# **Portishead Branch Line (MetroWest Phase 1)**

TR040011

9.9.1 ExA.LIR.D2.V1 – Applicant's response to the Bristol City Council Local Impact Report

**Date: November 2020**

2.48 - Ashton Vale Road Pedestrian Ramp Design Plan

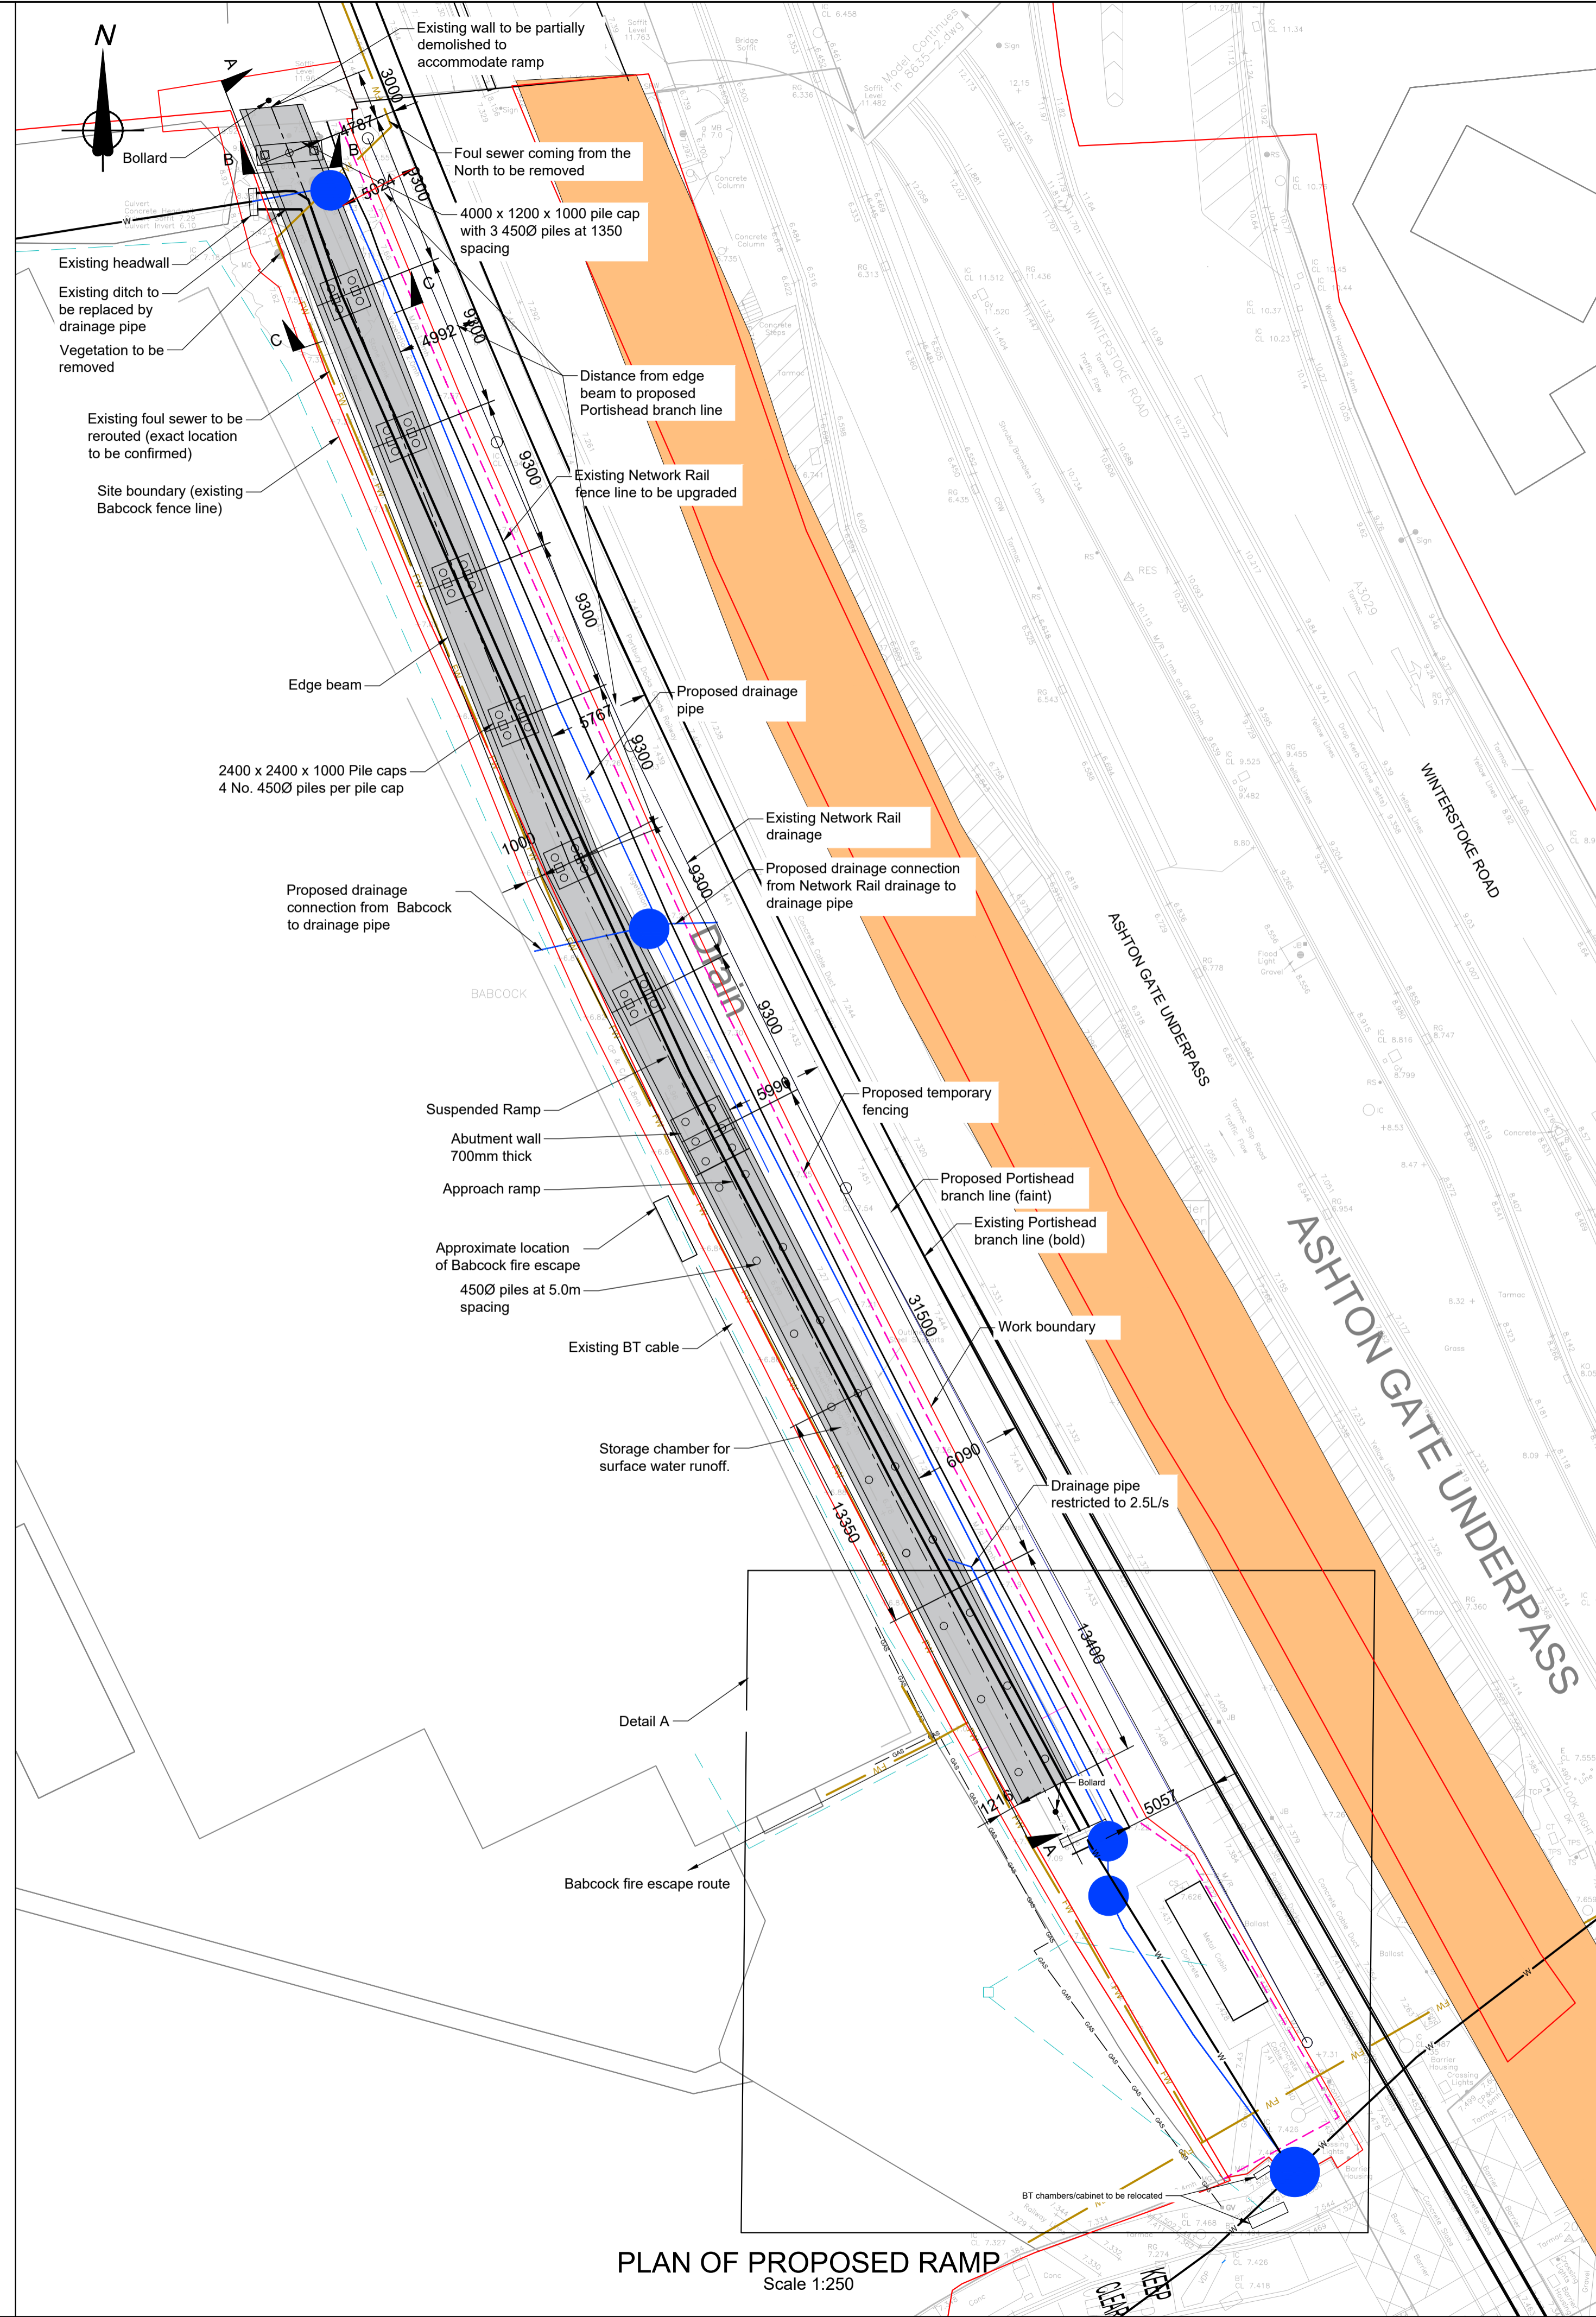
- 41. The dedication of the new public right of way (PRoW) at Winterstoke Road/Ashton Vale Road would enhance walking and cycling connectivity in accordance with Policy BCS10.

The Applicant refers to the draft SoCG with BCC (9.3.2 ExA.SoCGBCC.D1.V1/REP1-017) where the matters are discussed further and agreed where appropriate.

2.47 - Ashton Vale Road and Winterstoke Road Highway Works Plan

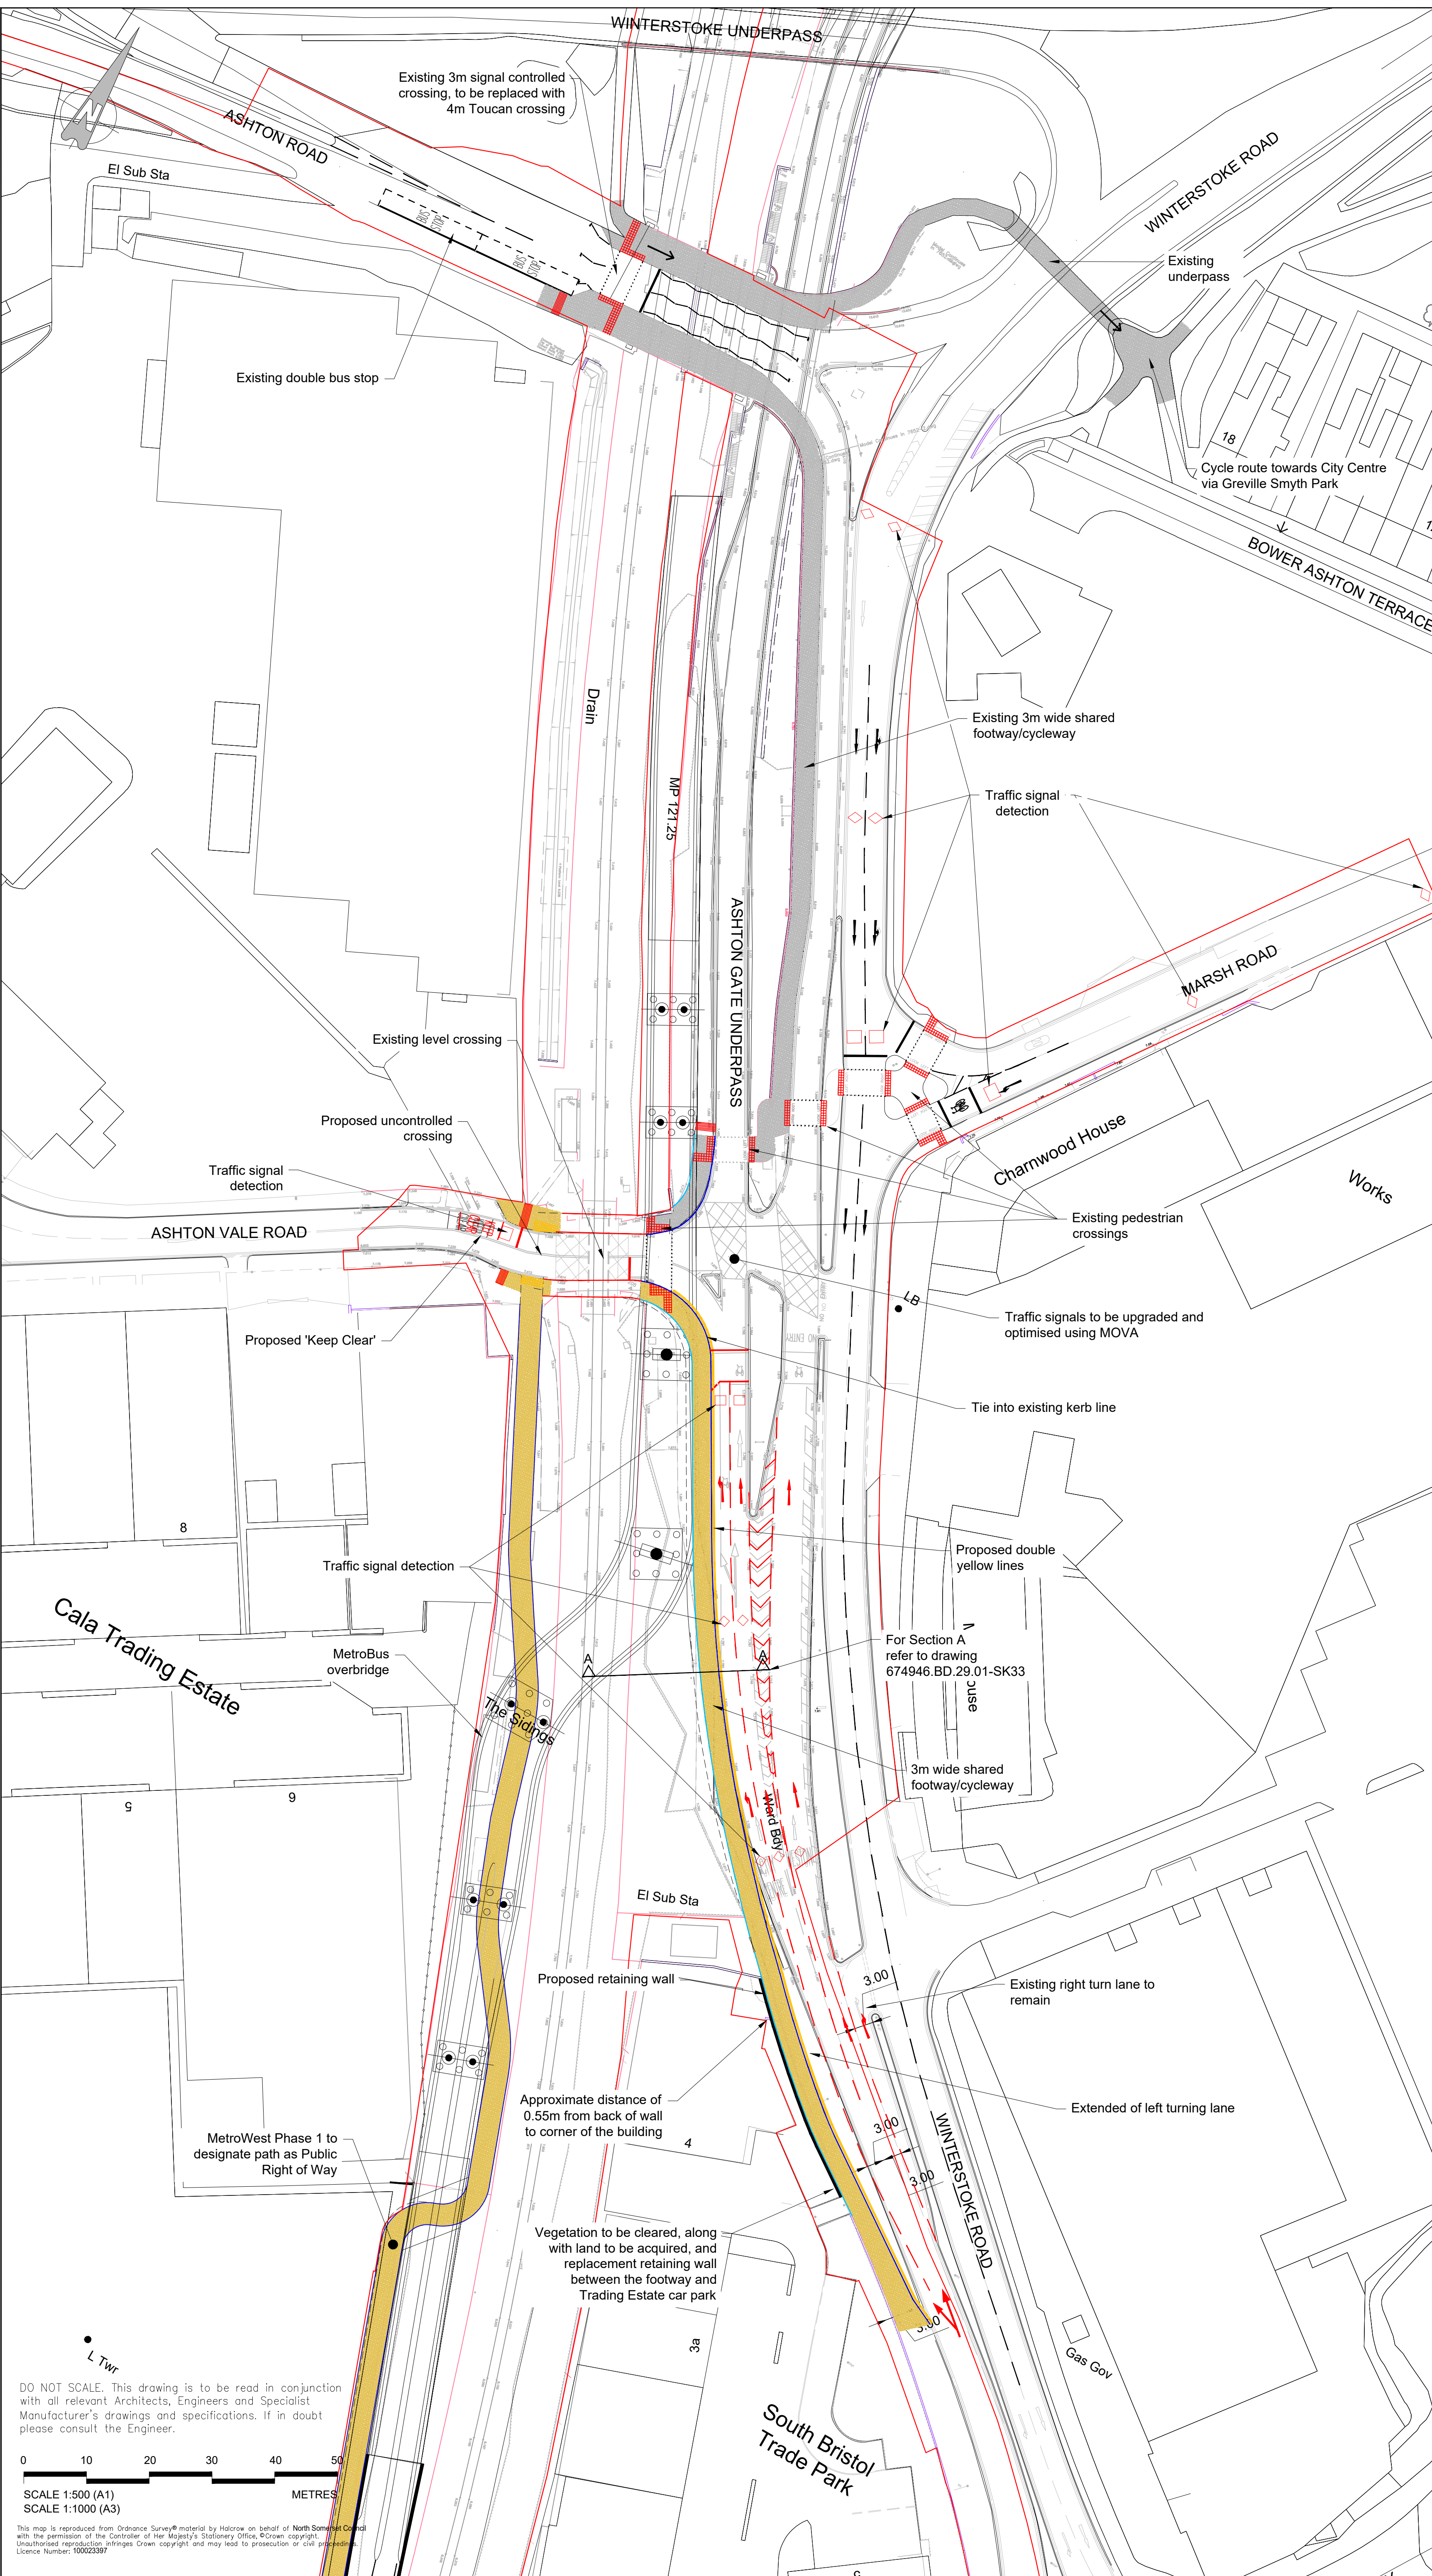
- 38. The Applicant has given sufficient consideration to the traffic impacts on Winterstoke Road and Ashton Vale Road. Provision of an extended left turn lane at this location, to mitigate potential impacts associated with the increased use of the Ashton Vale Level Crossing, is supported. It is noted within the traffic modelling results submitted by the Applicant that the hourly train service can be delivered without detriment to the highway at Winterstoke Road and Ashton Vale Road junction. Ongoing consultation with BCC's Network Management Team is encouraged and the detailed design

- 39. The Applicant has given sufficient consideration to the traffic impacts on Winterstoke Road and Ashton Vale Road. Provision of an extended left turn lane at this location, to mitigate potential impacts associated with the increased use of the Ashton Vale Level Crossing, is supported. It is noted within the traffic modelling results submitted by the Applicant that the hourly train service can be delivered without detriment to the highway at Winterstoke Road and Ashton Vale Road junction. Ongoing consultation with BCC's Network Management Team is encouraged and the detailed design for this aspect should be in accordance with BCC's Traffic Signals team.

- 42. Financial contributions would be required to implement the upgrade to MOVA on the signalised junction of Winterstoke Road / Ashton Vale Road and for a Traffic Regulation Order (TRO) to enable the Ashton Road Pelican crossing to be replaced with a Toucan crossing.
